From: [REDACTED]
Sent: 14 January 2026 16:56
To: Keadby Next Generation
Subject: Keadby Next Generation Power Station (EN0110001) - Additional Submission: Objection to CHP Assessment

Further to my registration enquiry of 14th January 2026, I am writing to submit a technical objection regarding the Applicant's Combined Heat and Power (CHP) Assessment v1 (dated 22nd September 2025).

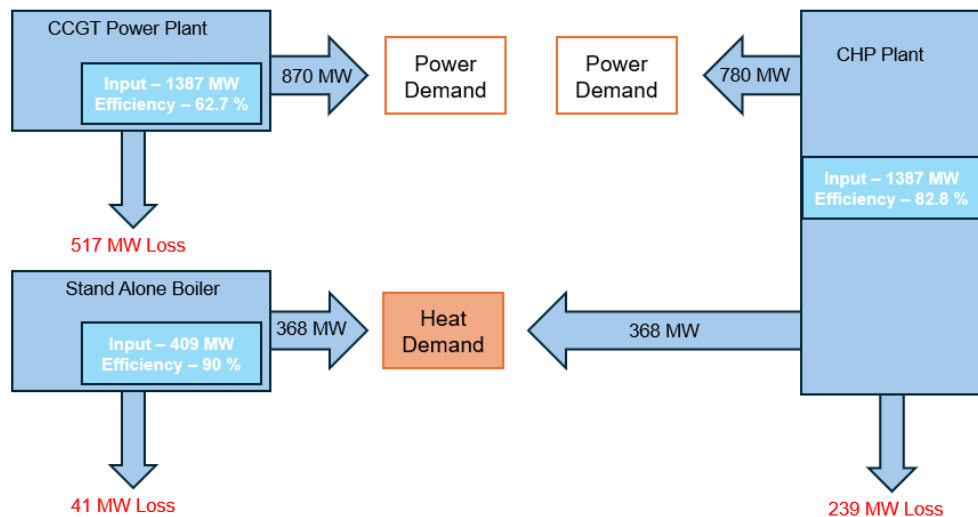
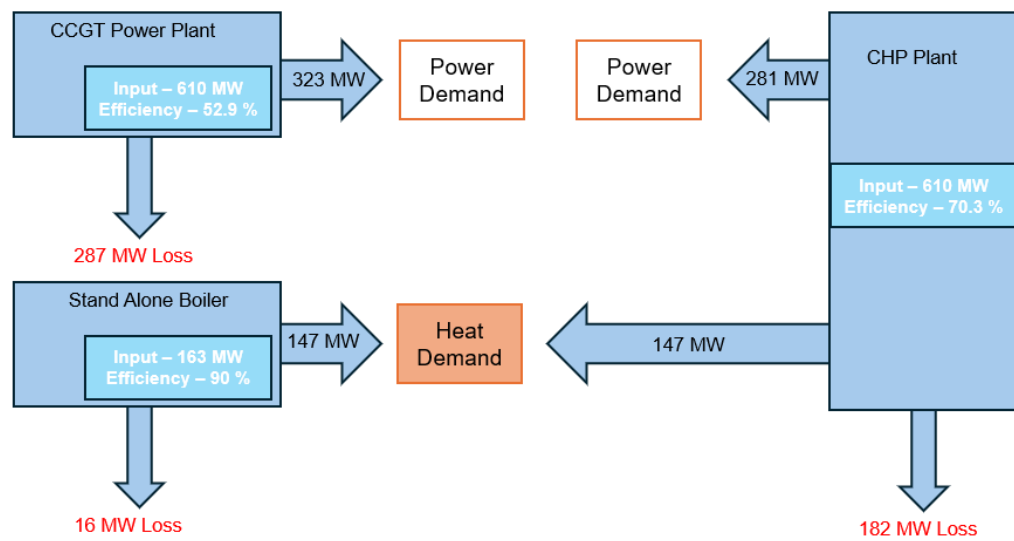
2. Erroneous Use of Primary Energy Savings (PES) In Section 2.4.1, the Applicant introduces Primary Energy Saved (PES) which in section 4.4.1 is used as a justification for not performing a CBA. This is a material error.

The Environmental Permitting Regulations 2016 do not list low PES scores as a valid exemption for conducting a CBA. PES is a metric for defining "High Efficiency CHP" after assessment; it is not a screening tool to avoid the assessment itself. The Applicant has conflated the outcome of a CBA with the requirement to perform one.

Plate 6: (Appendix B) Results from the examination of the UK CHP Development Map: Total heat demand map

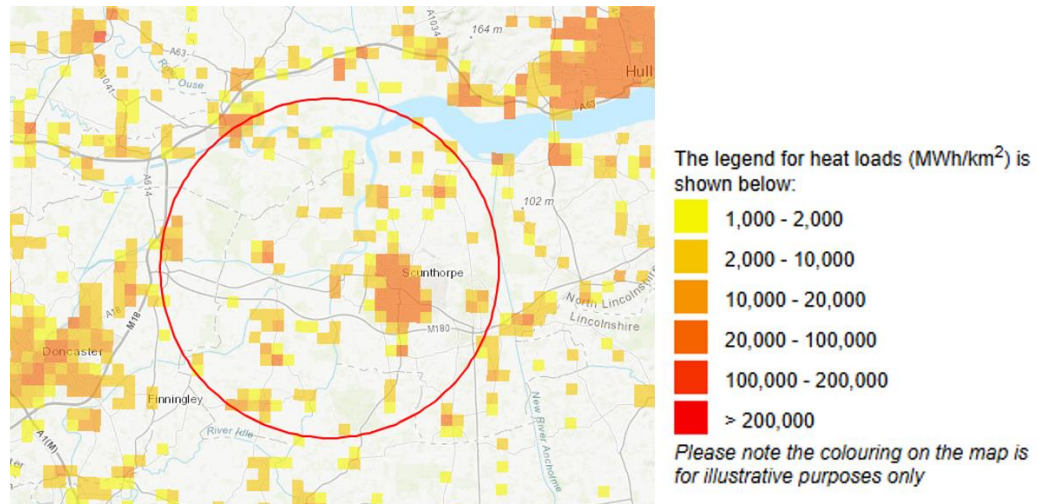
1. Misapplication of the 15km Search Radius In Section 4.1.1, the Applicant restricted their heat demand search to a 15km radius. This appears to be implicitly relying on the cost-benefit analysis exemption criteria in [Schedule 24](#), Paragraph 5 of the Environmental Permitting (England and Wales) Regulations 2016.

However, this 15km search radius applies specifically to exemptions for "Installations generating waste heat" (Paragraph 3) and "Heating and cooling networks" (Paragraph 4). The Keadby project falls under Paragraph 2 ("Electricity generating installations"), which is explicitly distinct from Paragraph 3.

There is no statutory provision in Schedule 24 that permits an electricity generating installation (Paragraph 2) to use the 15km radius as a hard limit to screen out Cost-Benefit Analysis (CBA). By applying an exemption designed for other waste heat sources, the Applicant has failed to assess the economic feasibility of longer-distance transmission (e.g., to Doncaster which is some 21km away), thereby failing the test in NPS EN-1 (2024), Paragraph 4.8.12 to "explain why CHP is not economically or practically feasible" based on actual project economics rather than arbitrary distance.
